Town Planning Accessibility Report

Oran Park High School & Public School Expansion

Report No: 16345-AC-Town Planning Report_Rev 01
Revision: 01
Date: 13 February 2017

Report Prepared for

ORAN PARK HIGH SCHOOL
& PRIMARY SCHOOL
SOUTH CIRCUIT & HOLDEN DRIVE
ORAN PARK NSW 2570
BLOCK HA & HB -
LEVEL 2 PLAN

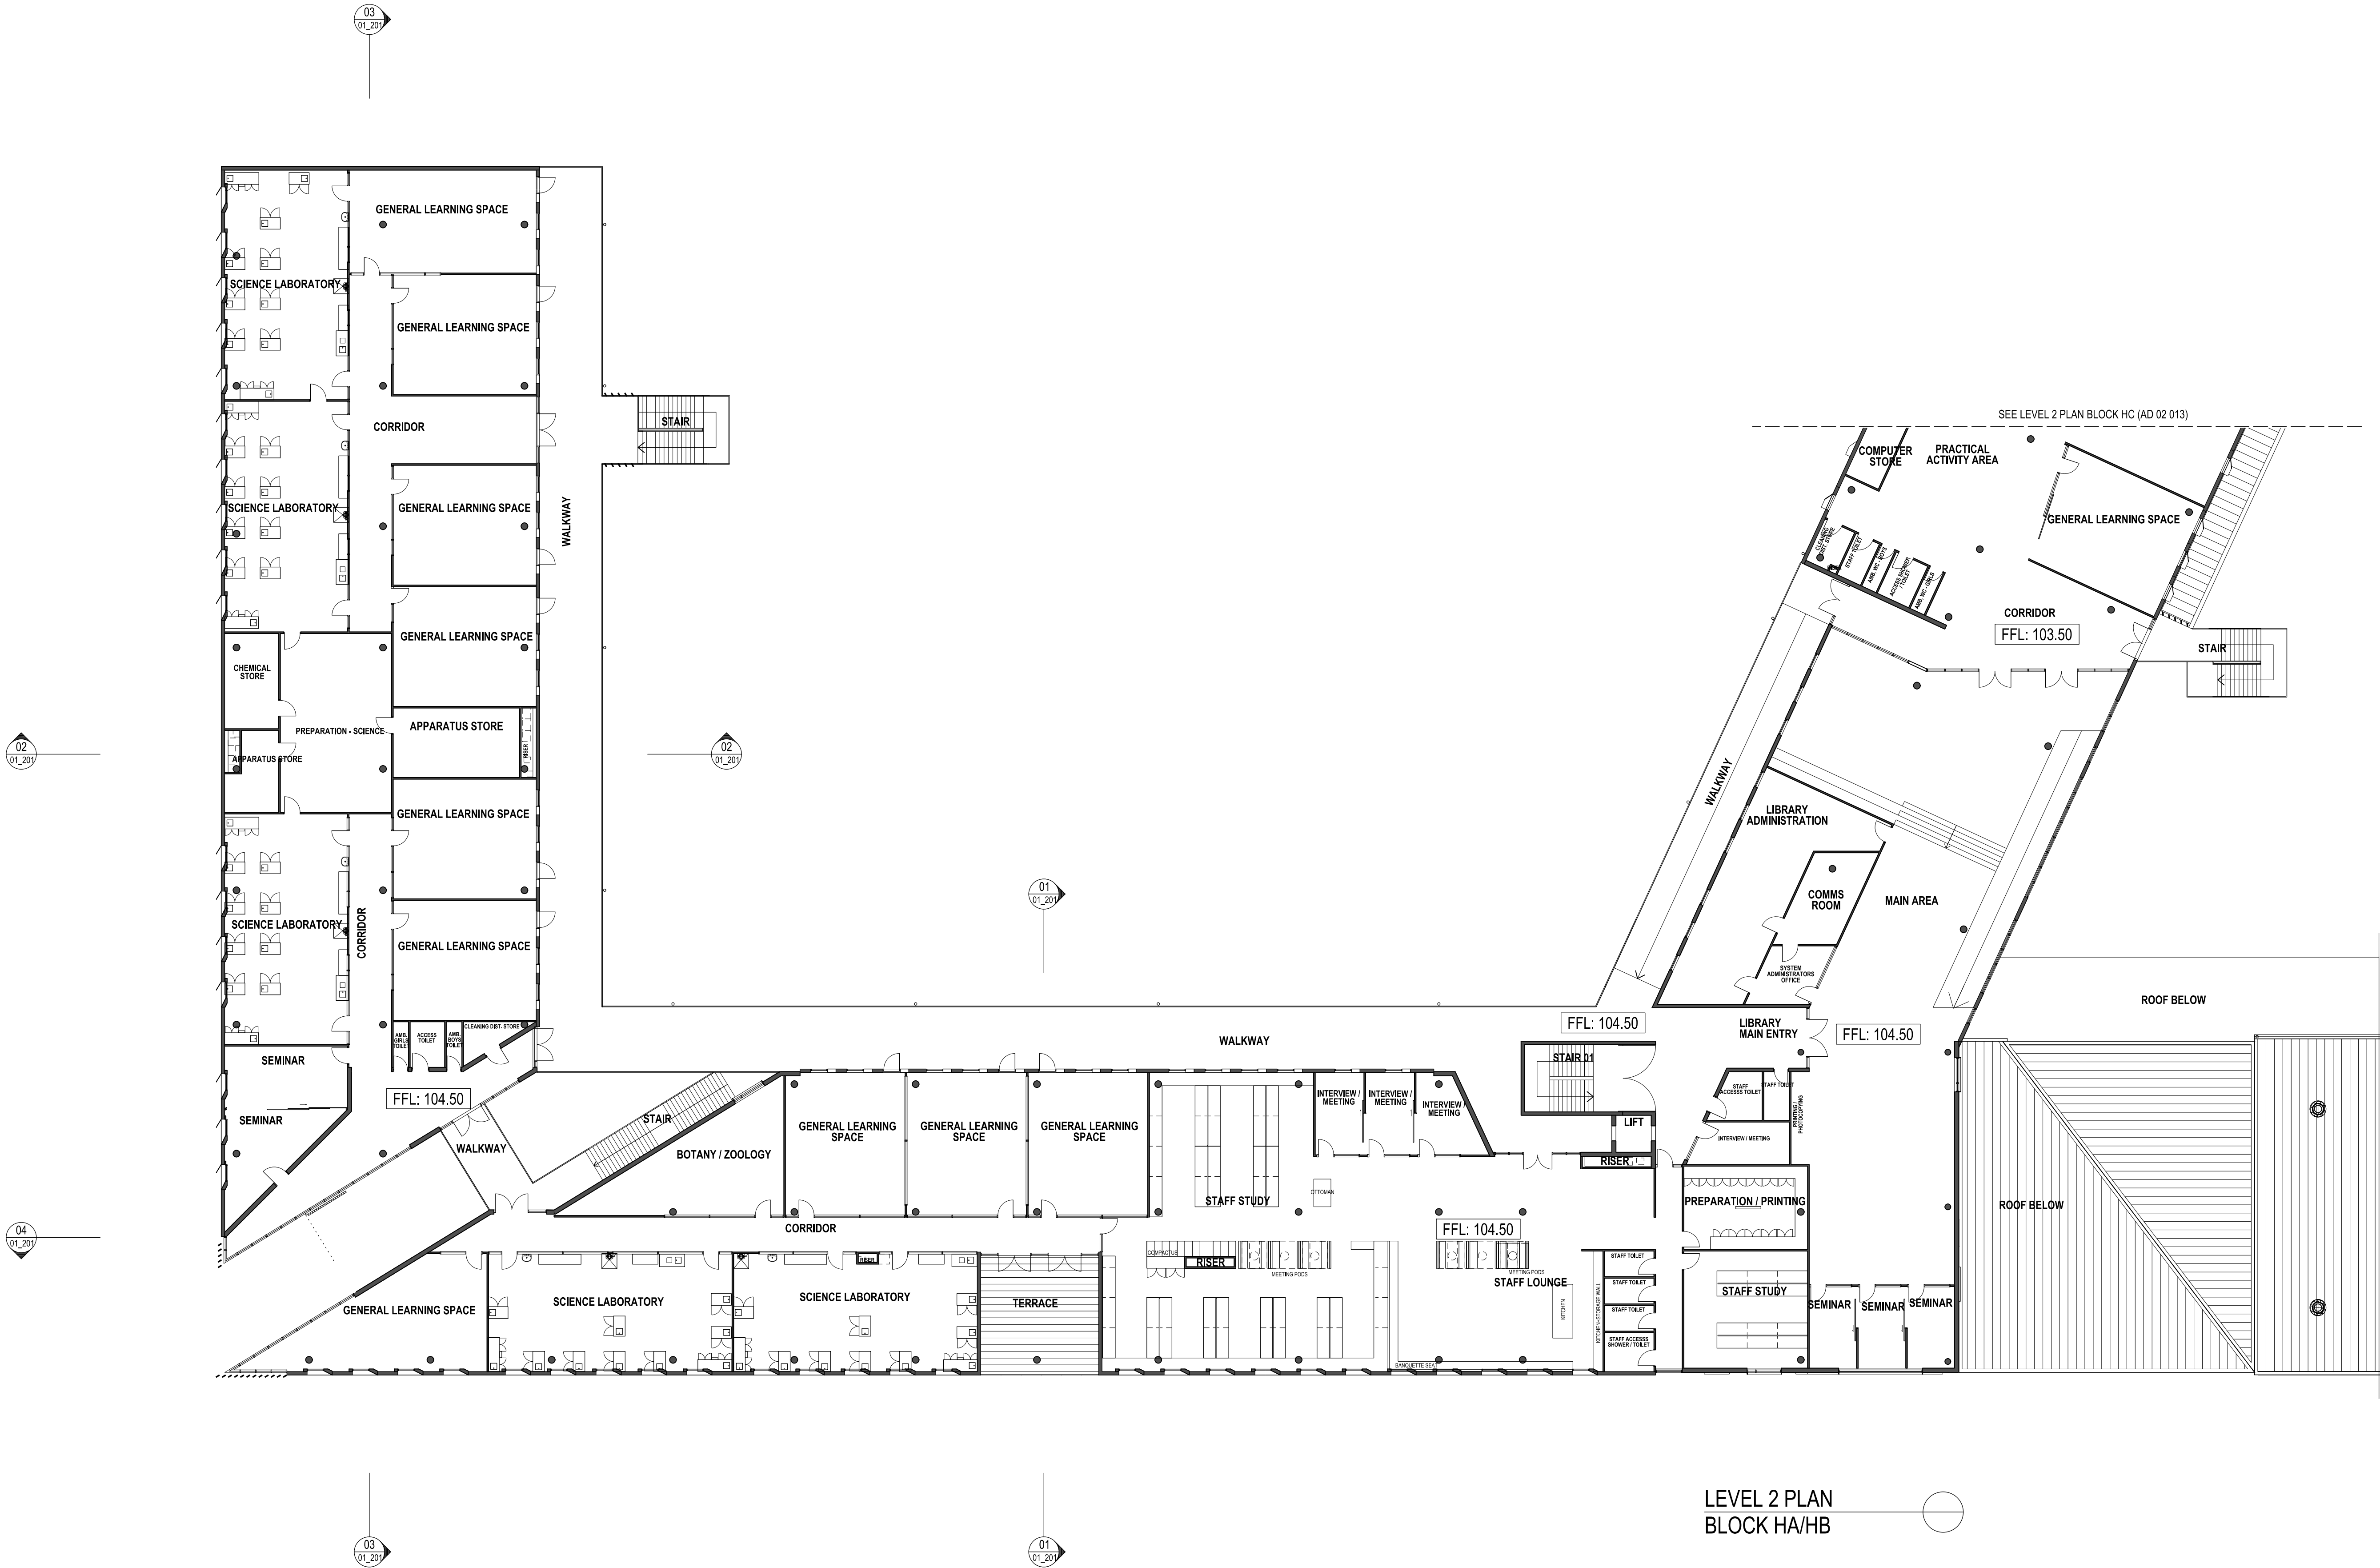
- 4.1.1 There is a concern with the location of the passenger lifts within Block HA & HB. The distance a person with a disability would need to travel to arrive at the same point as a person without a disability is quite significant due to the location of the lifts. It should be noted that the lift location is not a BCA issue. The BCA only calls for access to all areas not distance of travel for people with disabilities. We are raising this issue to identify that it could be a possible complaint under the Disability Discrimination Act as a person with a disability is being treated differently or unfairly.

There are two means of mitigating the risk. Firstly install a lift at the elbow of the Block to reduce the distance of travel or the State accepts the risk and develops a management plan to schedule students or staff with disabilities to classrooms in closer proximity. This may require duplicating unique facilities and/or relocating classes.
